**KIRKLEES METROPOLITAN COUNCIL
INVESTMENT & REGENERATION SERVICE**

DELEGATED DECISION TO DETERMINE APPLICATIONS FOR LISTED BUILDING CONSENT

Reference No:	2025/65/92733/E
Site Address:	Grange Cottage, Kirkby Grange Farm, Clough Road, Flockton, Huddersfield, WF4 4AQ
Description:	Listed Building Consent for replacement windows, installation of rooflights, alterations to chimney and associated works
Recommending Officer:	Elenya Jackson

title As proposed plans and sections
number GC-03-P03
scale 1:50
size A1

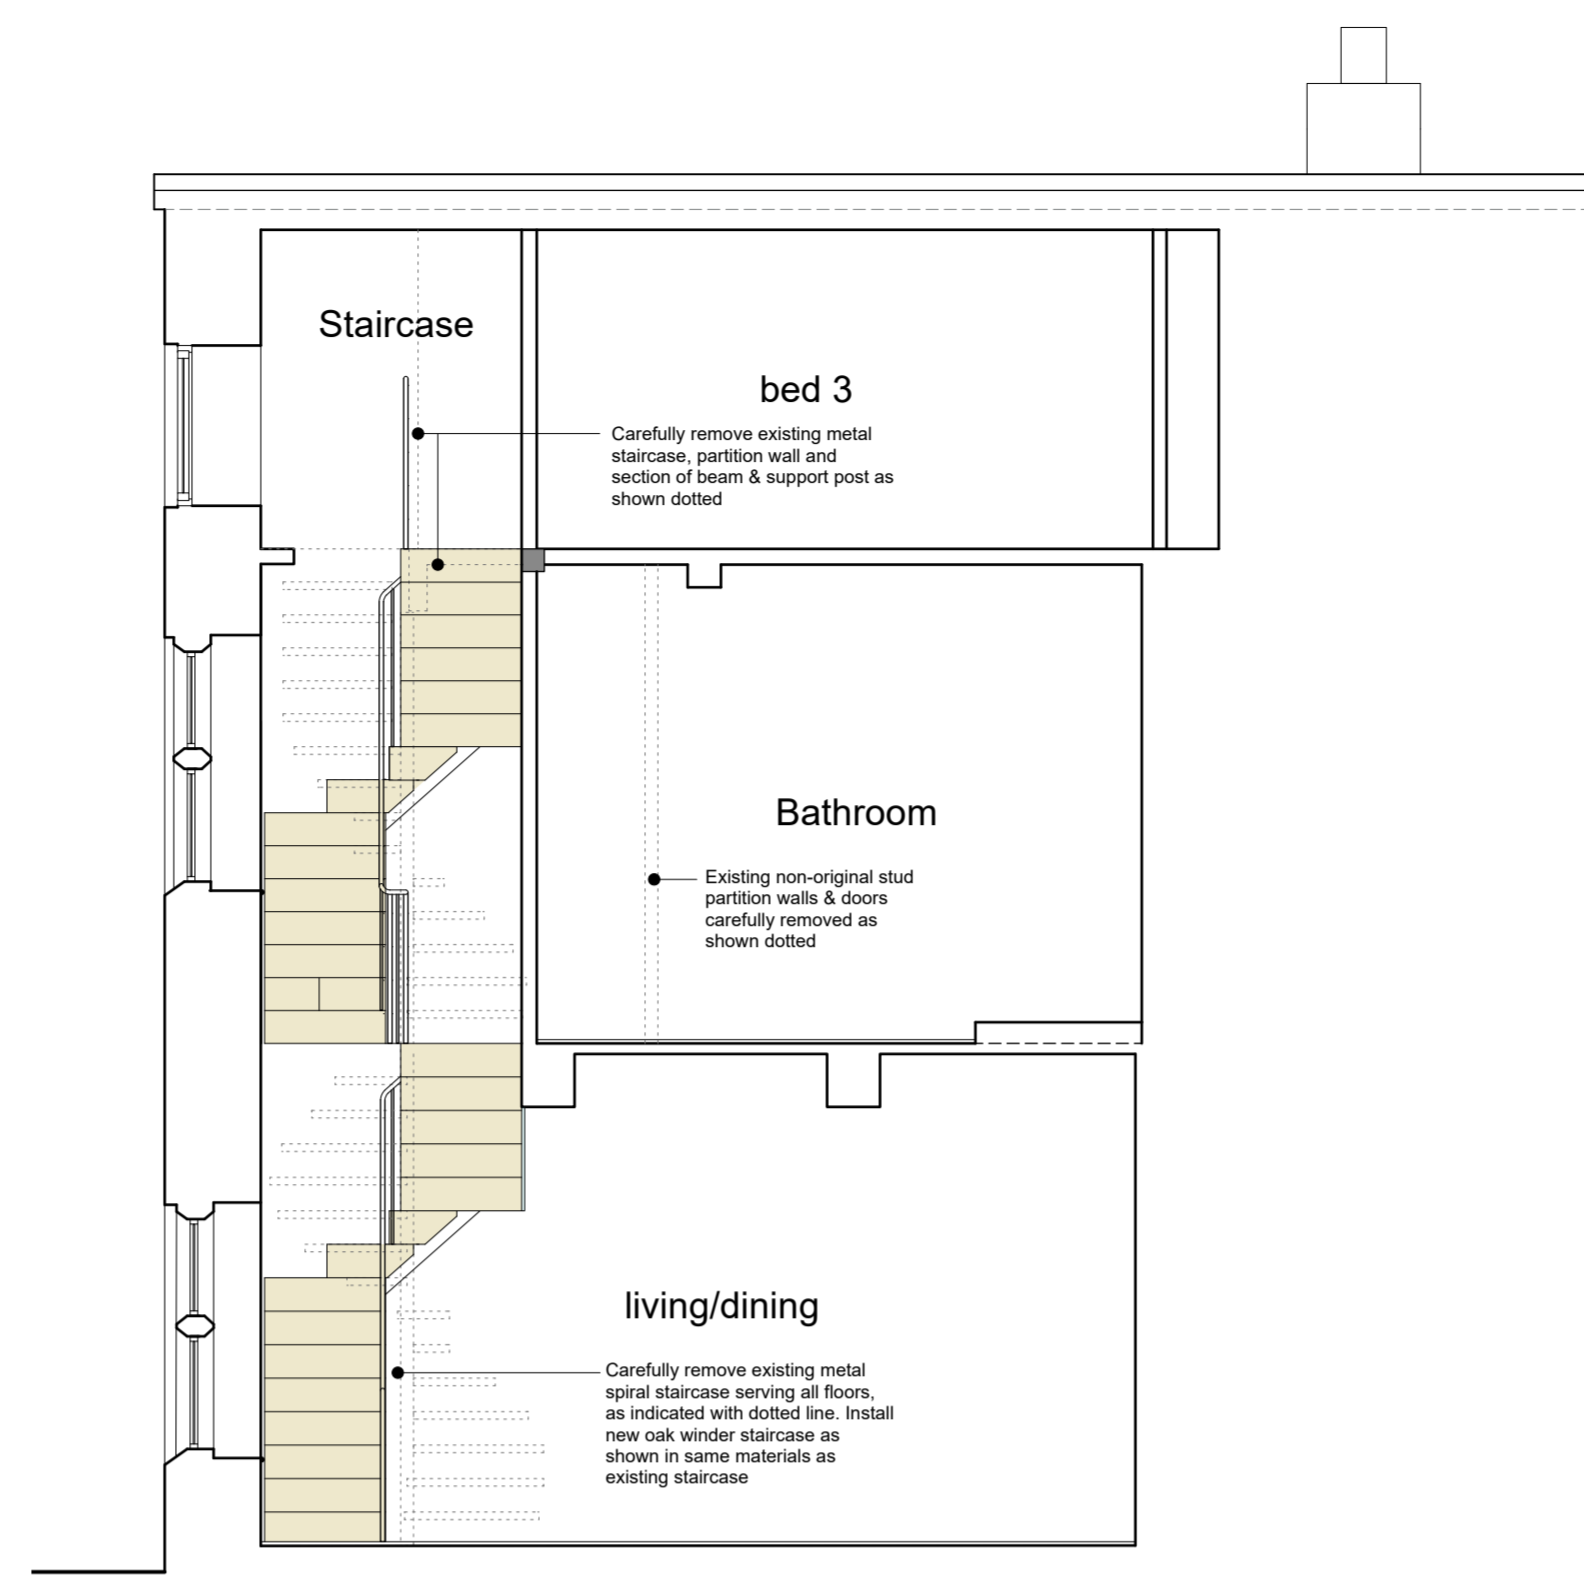
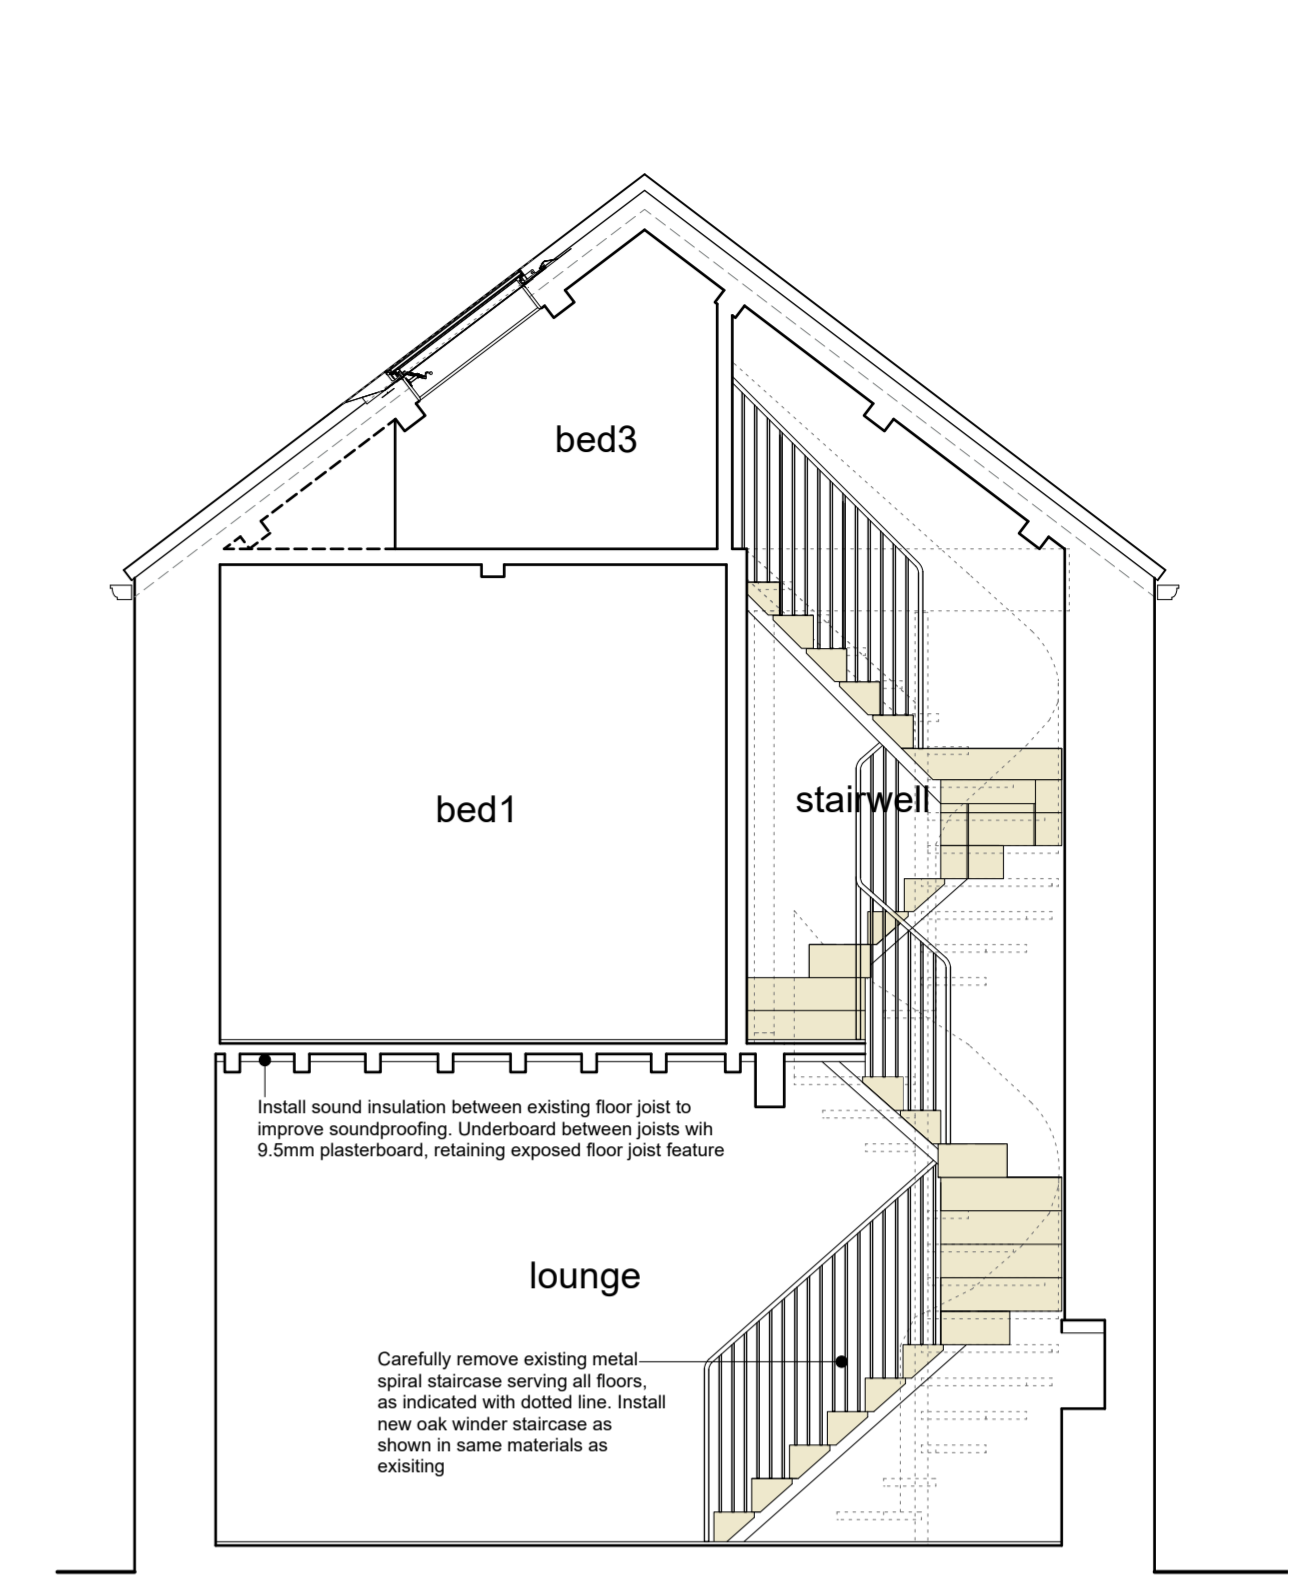
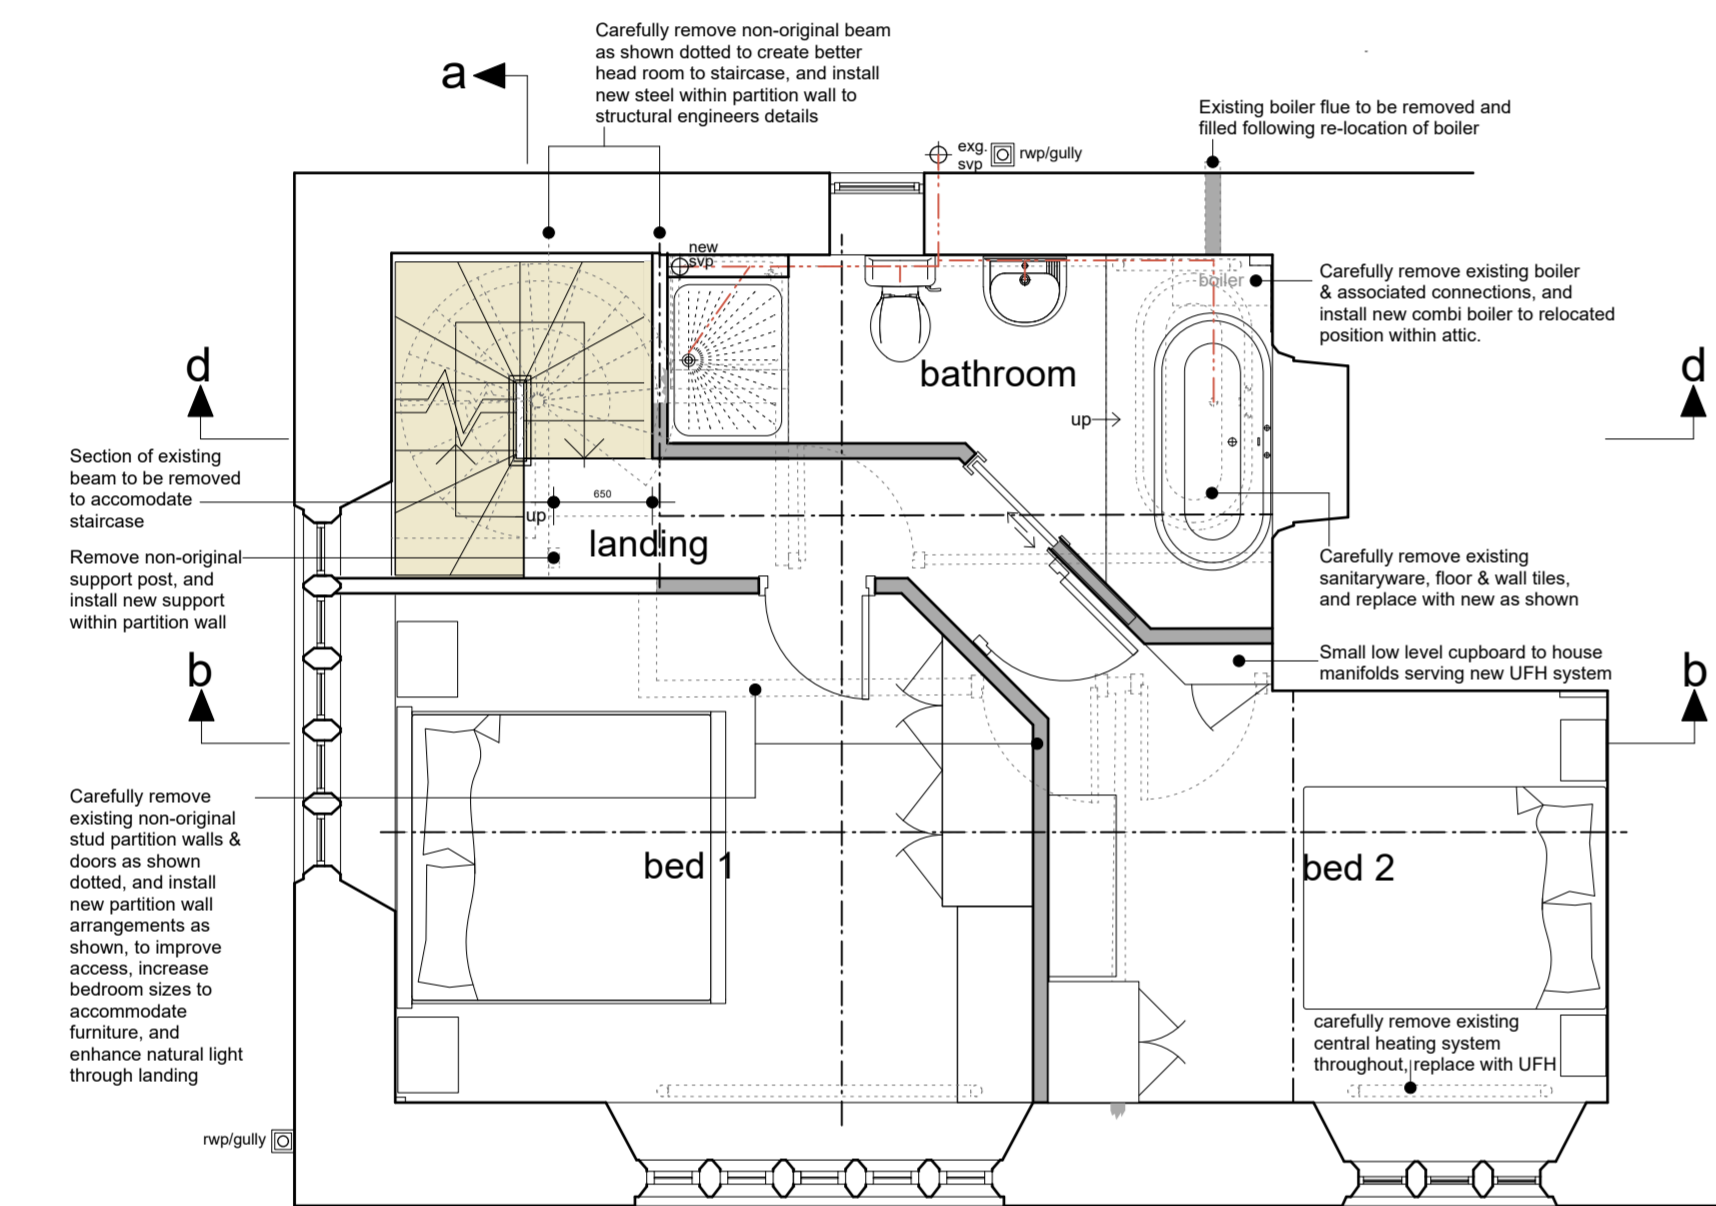
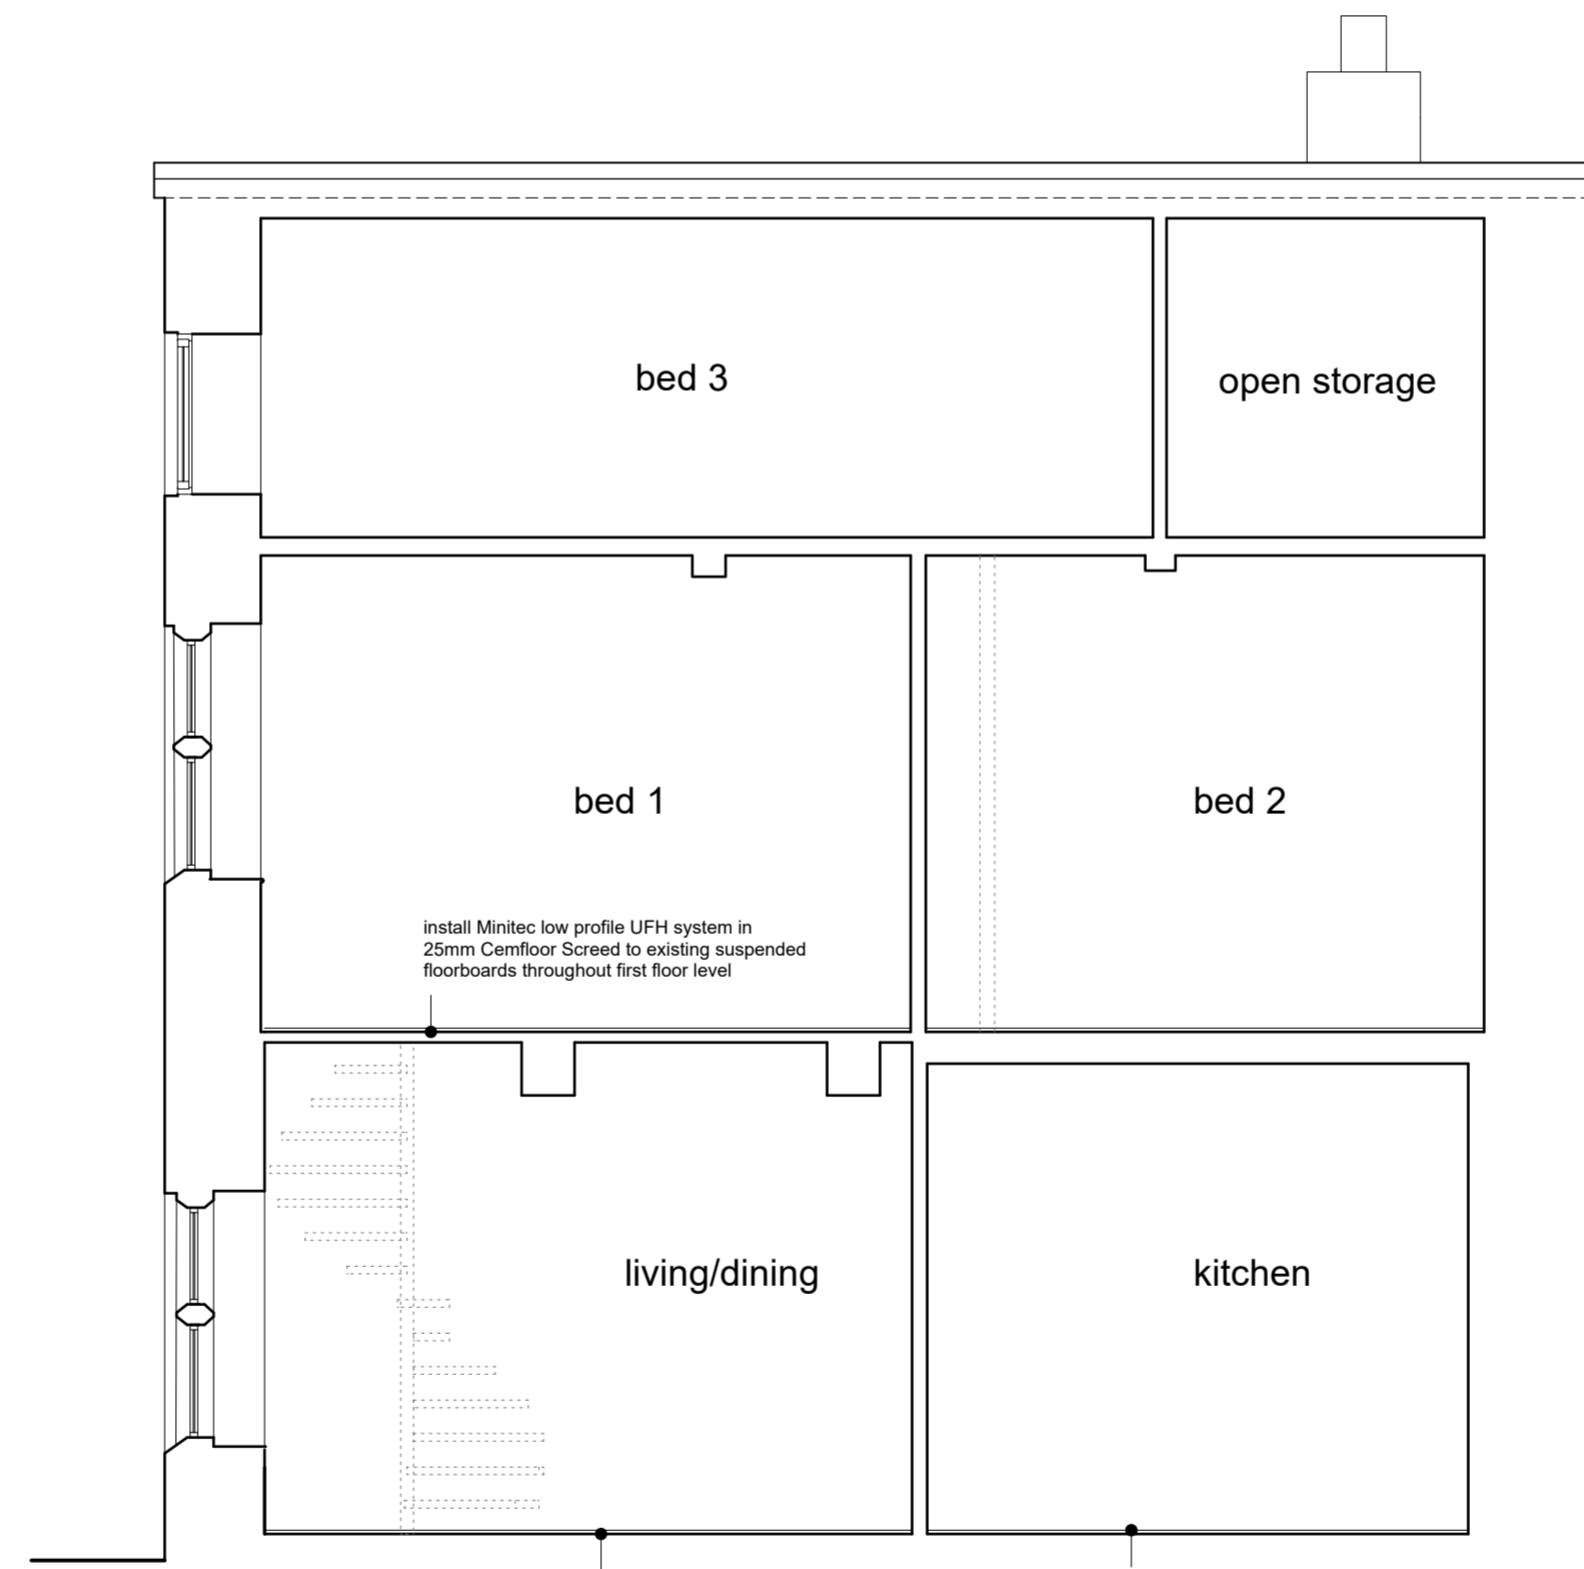
During the course of the application, alterations were requested to reduce the number of roof lights, amend the doors to be more in keeping with the historic character and change to proposed staircase to feature less glazing..

KC Conservation & Design (informal) – The Conservation & Design Team requested alterations to the design of the proposal which sought reductions to the number of roof lights, alterations to the internal staircase, alterations to the internal doors. Amended plans have been provided and the application has been progressed on this basis.

5. Notwithstanding the submitted details, details of the proposed staircase are to be submitted and agreed by the Local Planning Authority prior to installation.
